# Kittitas County Community Development Services

Date: April 19, 2005  
To: Kittitas County CDS  
Jan Sharar, Staff Planner  
From: Derald Gaidos, Fire Marshal  
RE: P-04-08 Mellergaard

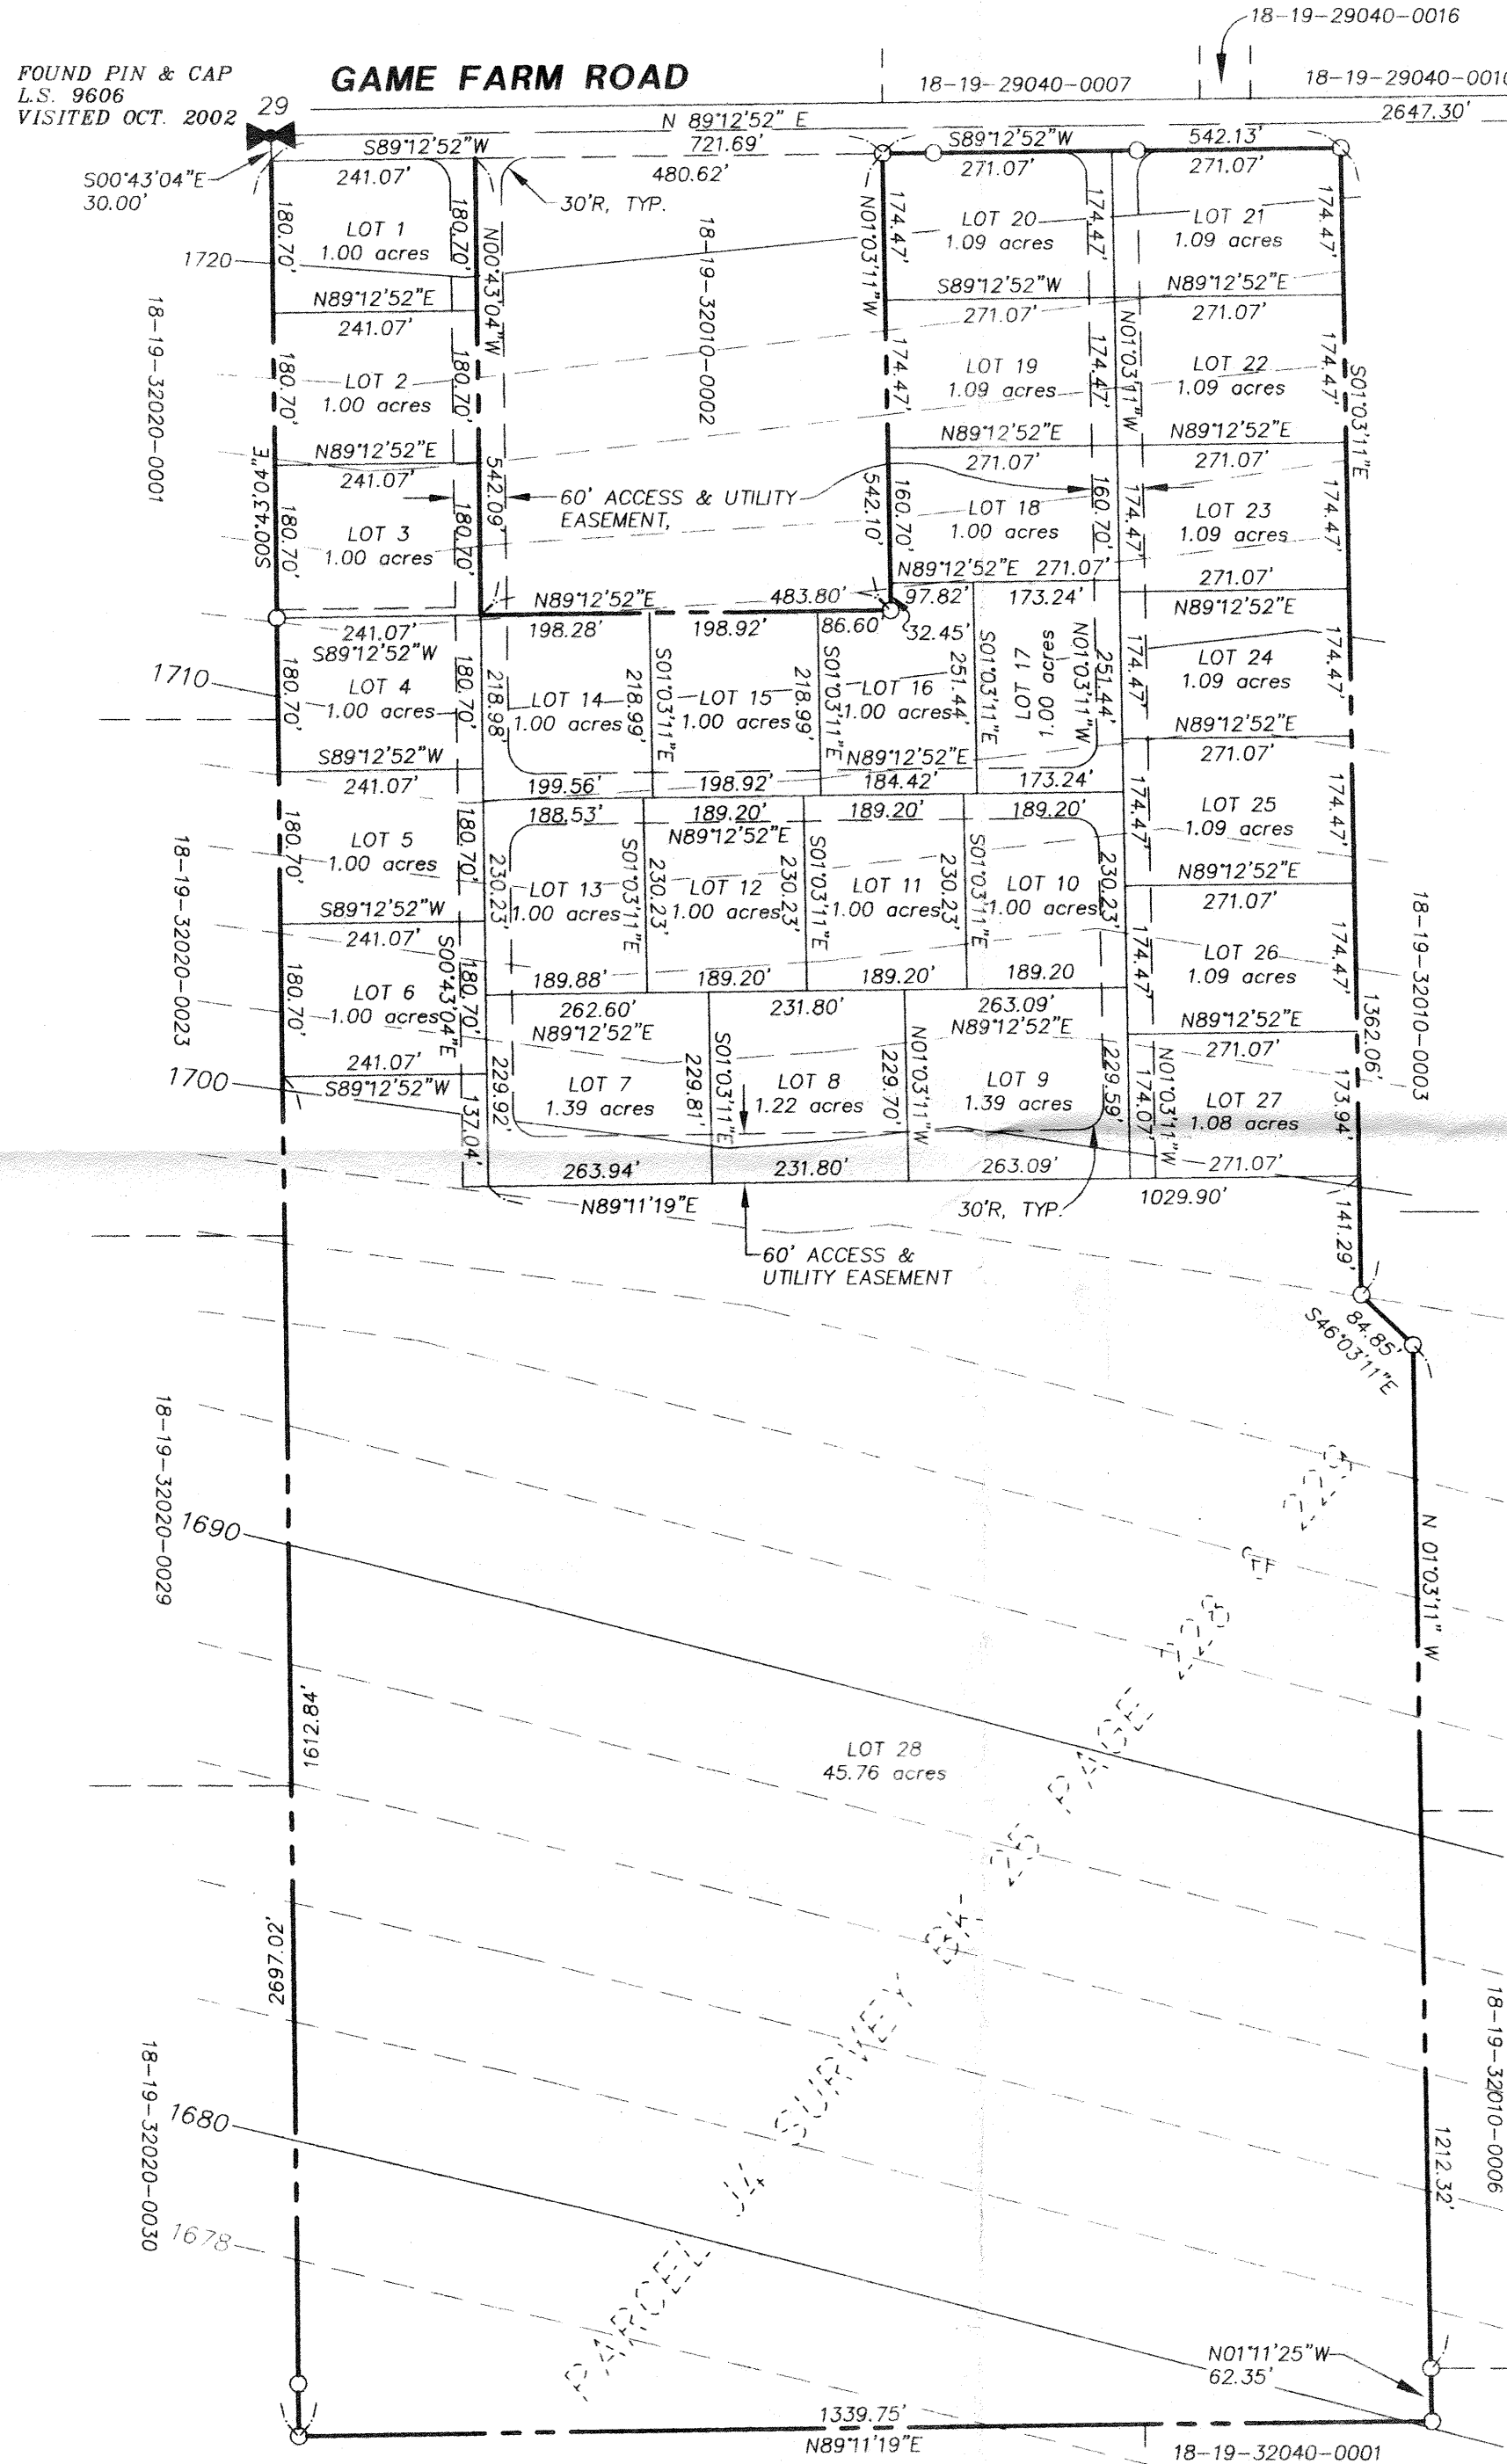
- Roads shall meet or exceeded Kittitas County Road Standards for emergency vehicle access.
- Fire Flow will be required for this development due to the density of lots. This can be accomplished with fire hydrants system, drafting ponds and or water tanks. 1000 GPM for 45 minutes of total storage capacity designated for fire fighting.
